# CITY OF ALBUQUERQUE

**Re: Broadstone Cottonwood  
Grading and Drainage Report  
Engineer's Stamp dated 4/24/13 (A13/D022)**

Based upon the information provided in your report received 4/26/2013, the above referenced report cannot be approved for Building Permit, Grading Permit or Work Order until the following comments are addressed:

ENGINEER'S SEAL RONALD R. BOHANNAN P.E. #7868	BROADSTONE COTTONWOOD GRADING AND DRAINAGE PLAN TIERRA WEST, LLC 5571 MIDWAY PARK PLACE NE ALBUQUERQUE, NM 87109 (505) 858-3100 www.tierrawestllc.com	DRAWN BY DY
		DATE 5/08/13
		2011043-G&D
		SHEET # GR-5

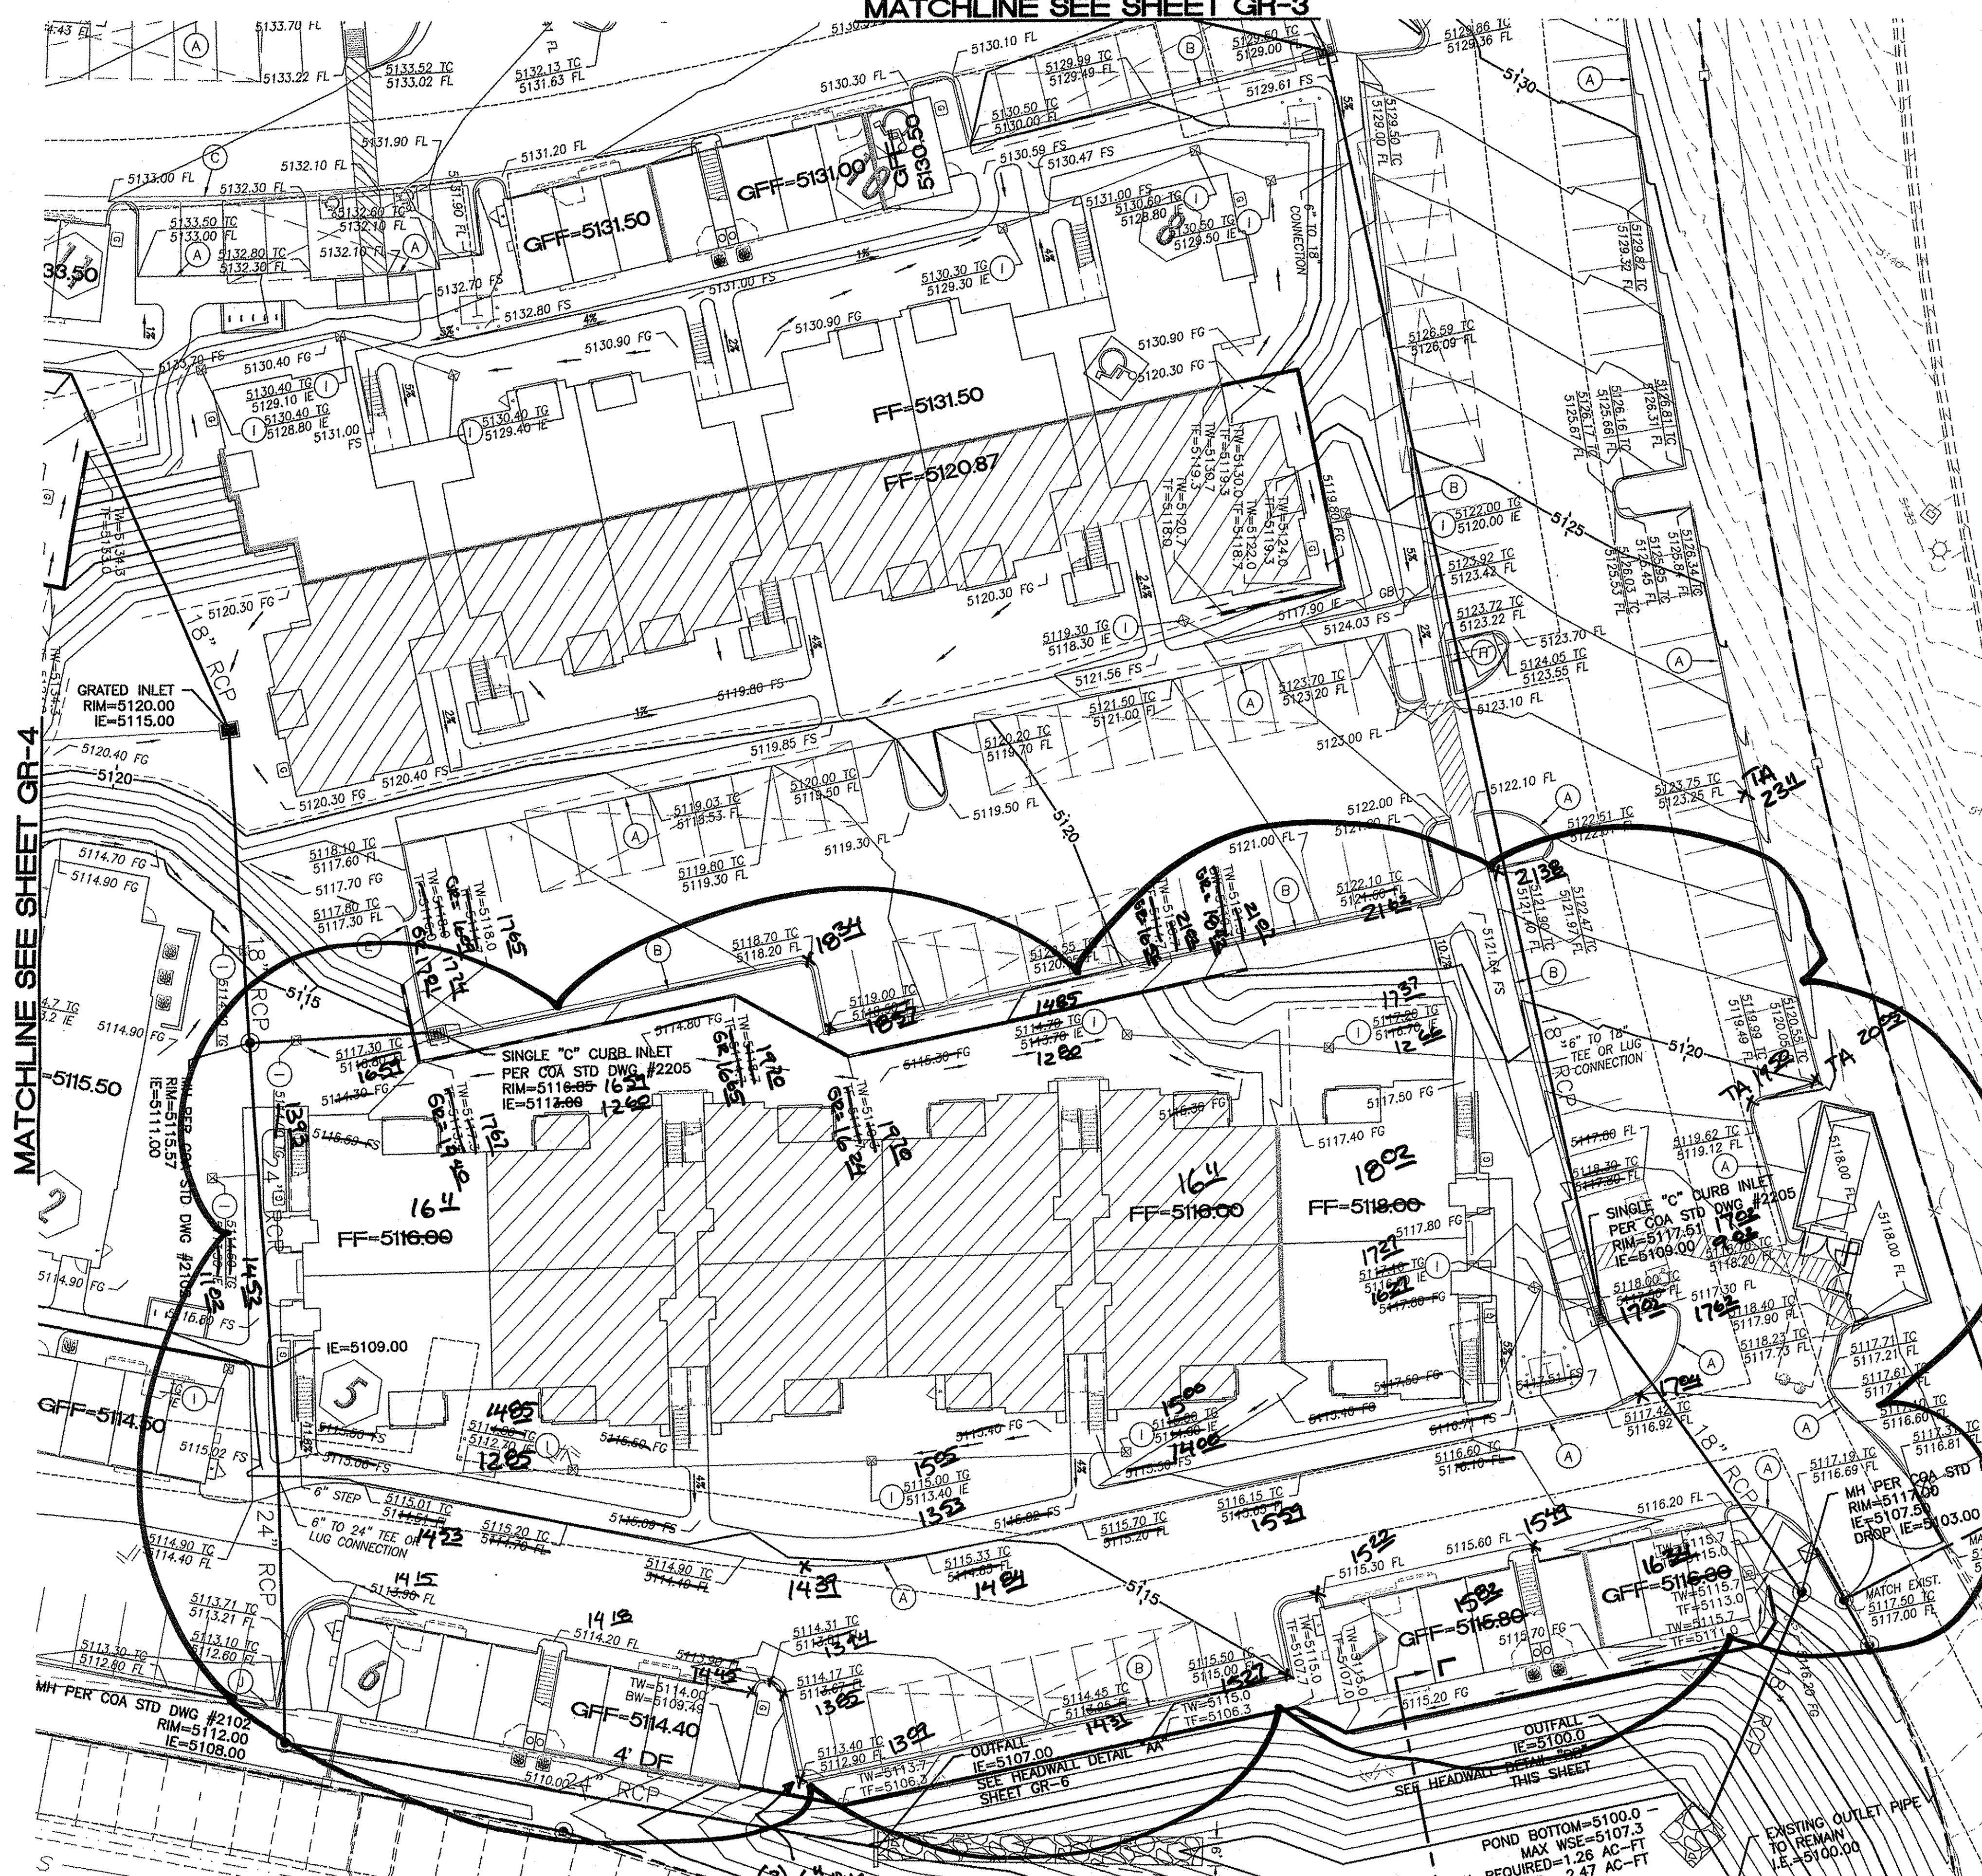
- In the profile section system B3 DI-4 and T-2 are written over each other and are not legible.
- The grading plan provided for the site does not adequately display how the flows are being diverted or retained in the landscaped areas around the buildings. Grades are needed for the areas around the buildings. Which direction are the roof flows? Sections of the walls surrounding this site should be provided. The plan should also be stamped, dated and signed.

ENGINEER'S SEAL	DRAWN BY	
		DY	
		DATE	
		8/01/13	
BROADSTONE COTTONWOOD		2011043-G&D	
OVERALL GRADING AND DRAINAGE PLAN		SHEET #	
TIERRA WEST, LLC		GR-1	
5571 MIDWAY PARK PLACE NE		JOB #	
ALBUQUERQUE, NM 87109		2011043	
(505) 858-3100			
www.tierrewestllc.com

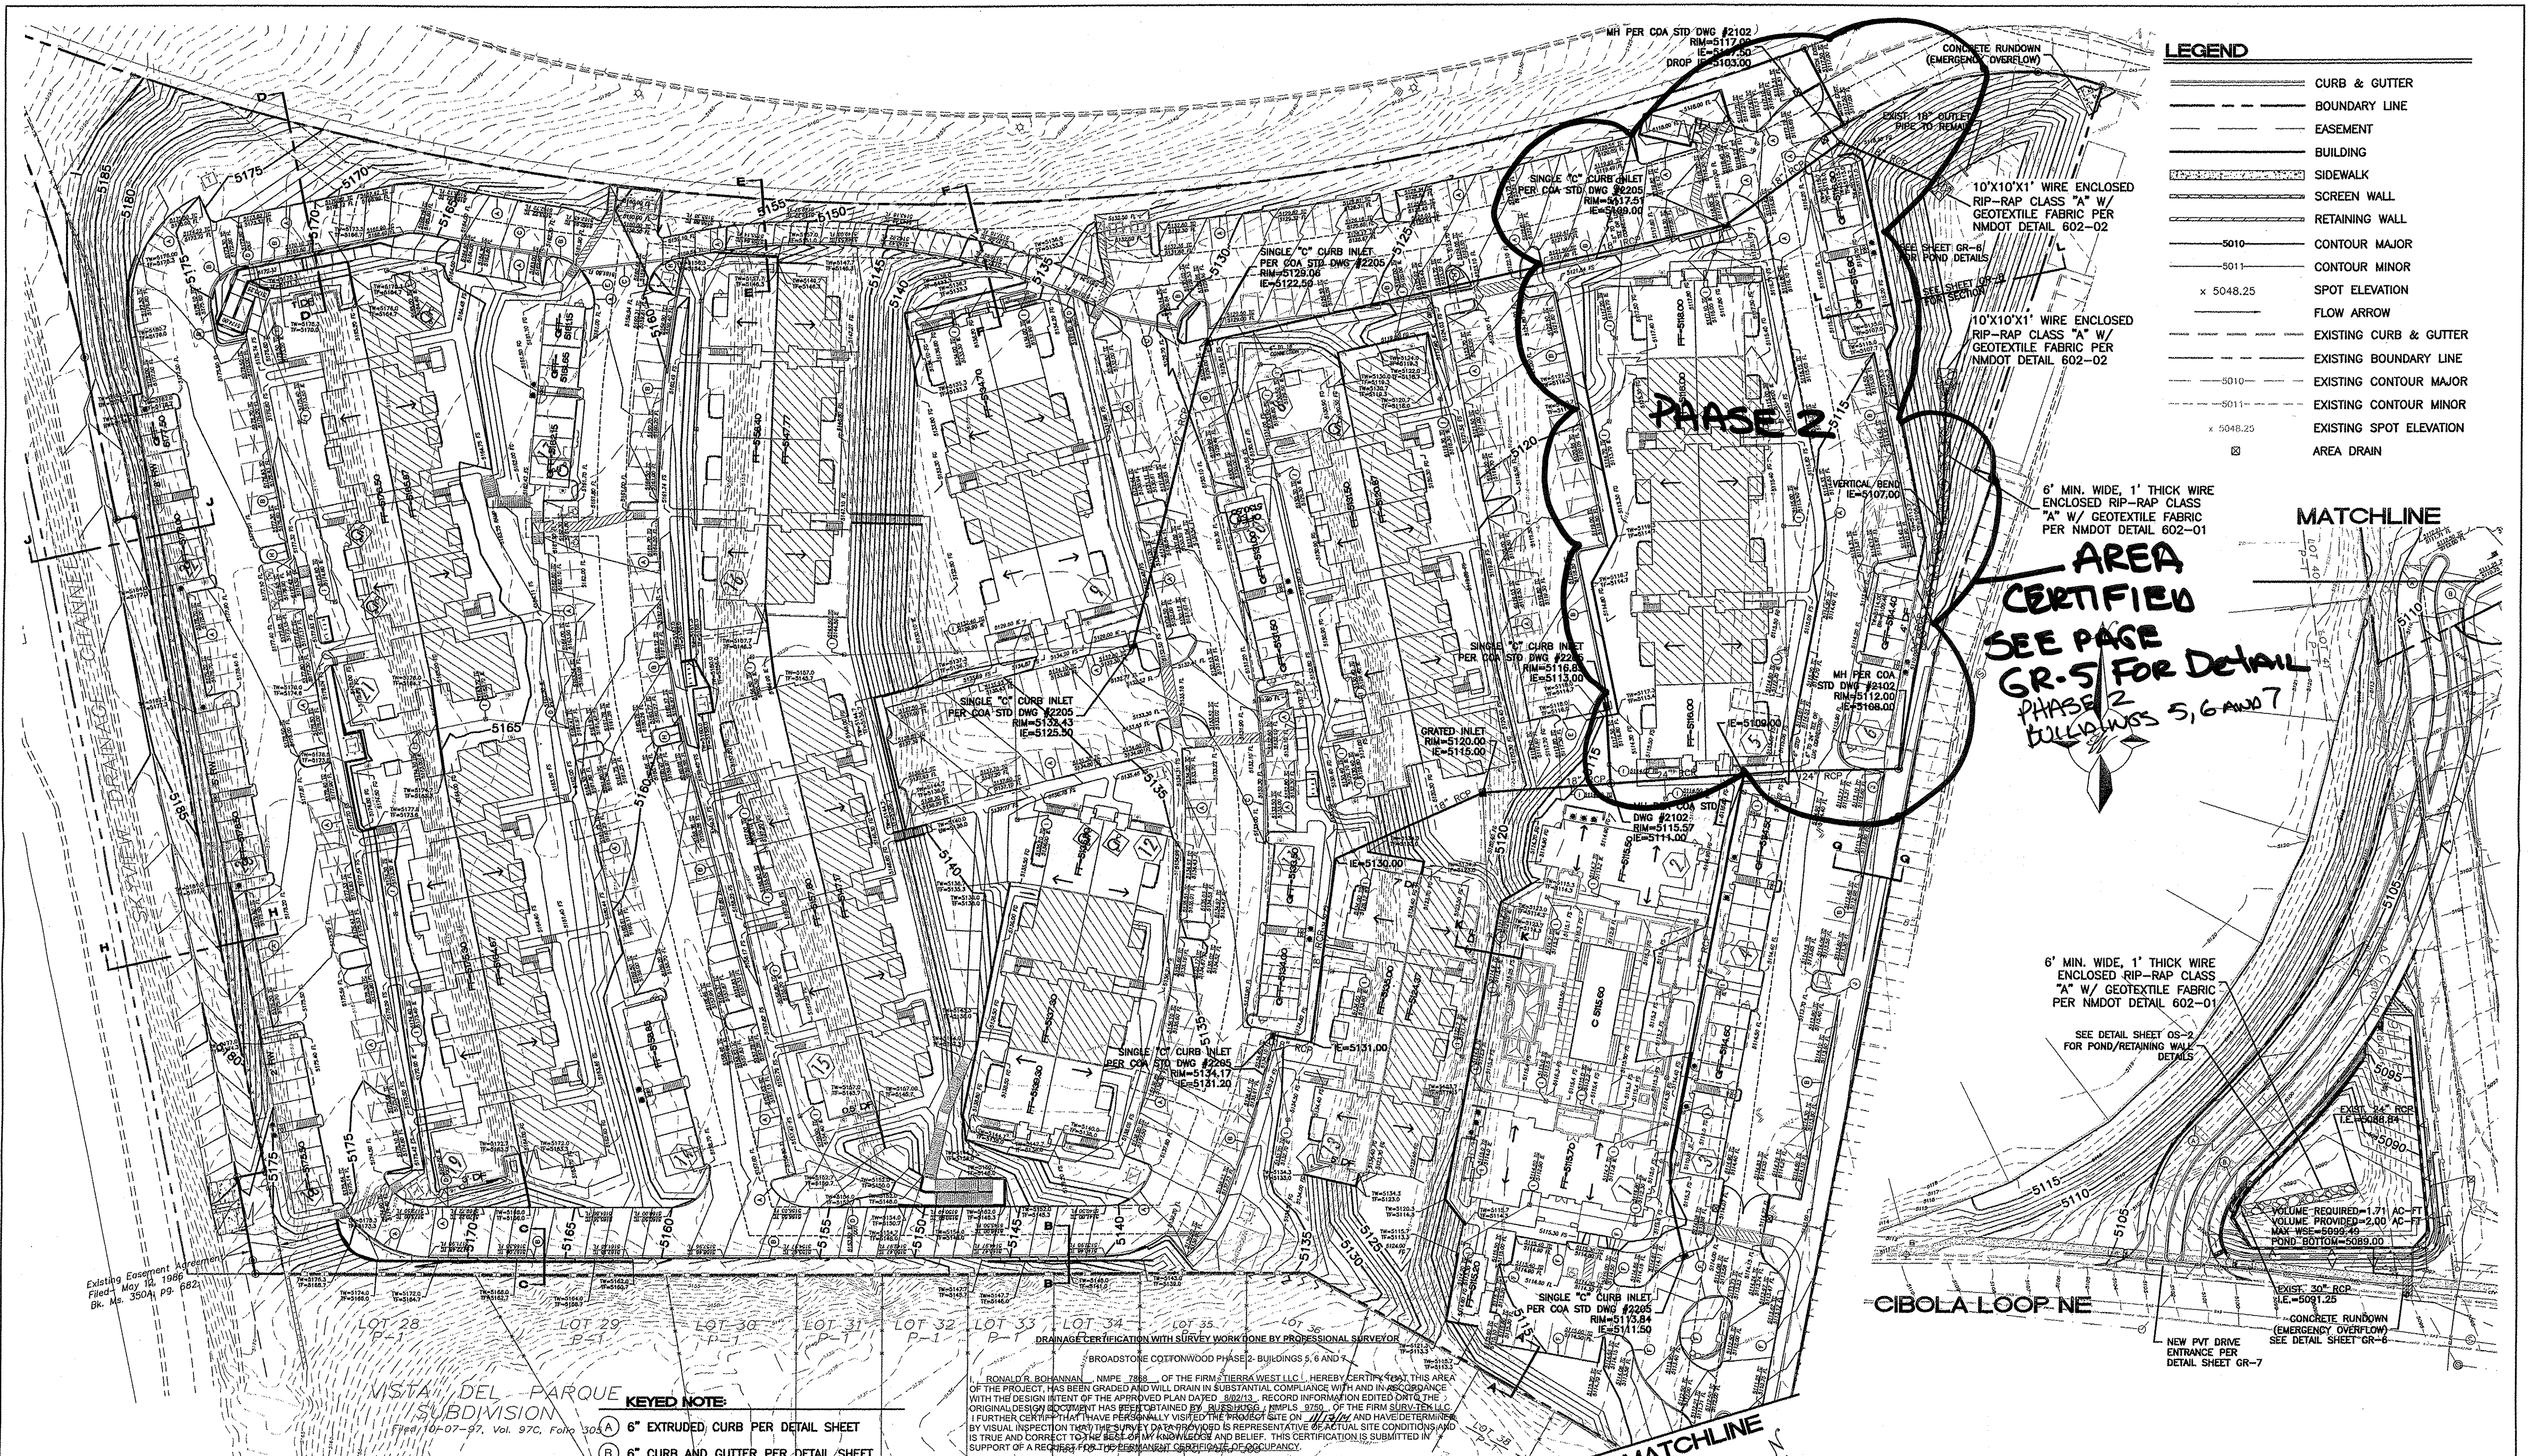
- How are the flows entering and exiting the Southeast pond? What are the inverts, the Volume required, the volume provided, the WSE? Is the existing pipe being removed and extended into the pond? Why is the maintenance access labeled future? What are the three blocks in the pond?

- The northeast pond needs rip-rap or some type of energy dissipater to prevent under cutting. A section should also be provided. Is this a retention pond or a detention pond? What are the inverts, the Volume required, the volume provided, the WSE and the pond bottom?

- An agreement and covenant is needed for the old city pond with DMD.
- An agreement with AMAFCA is needed.
- Show existing Topography.
- Provide details for both emergency overflows. Flows should not over top public sidewalks.
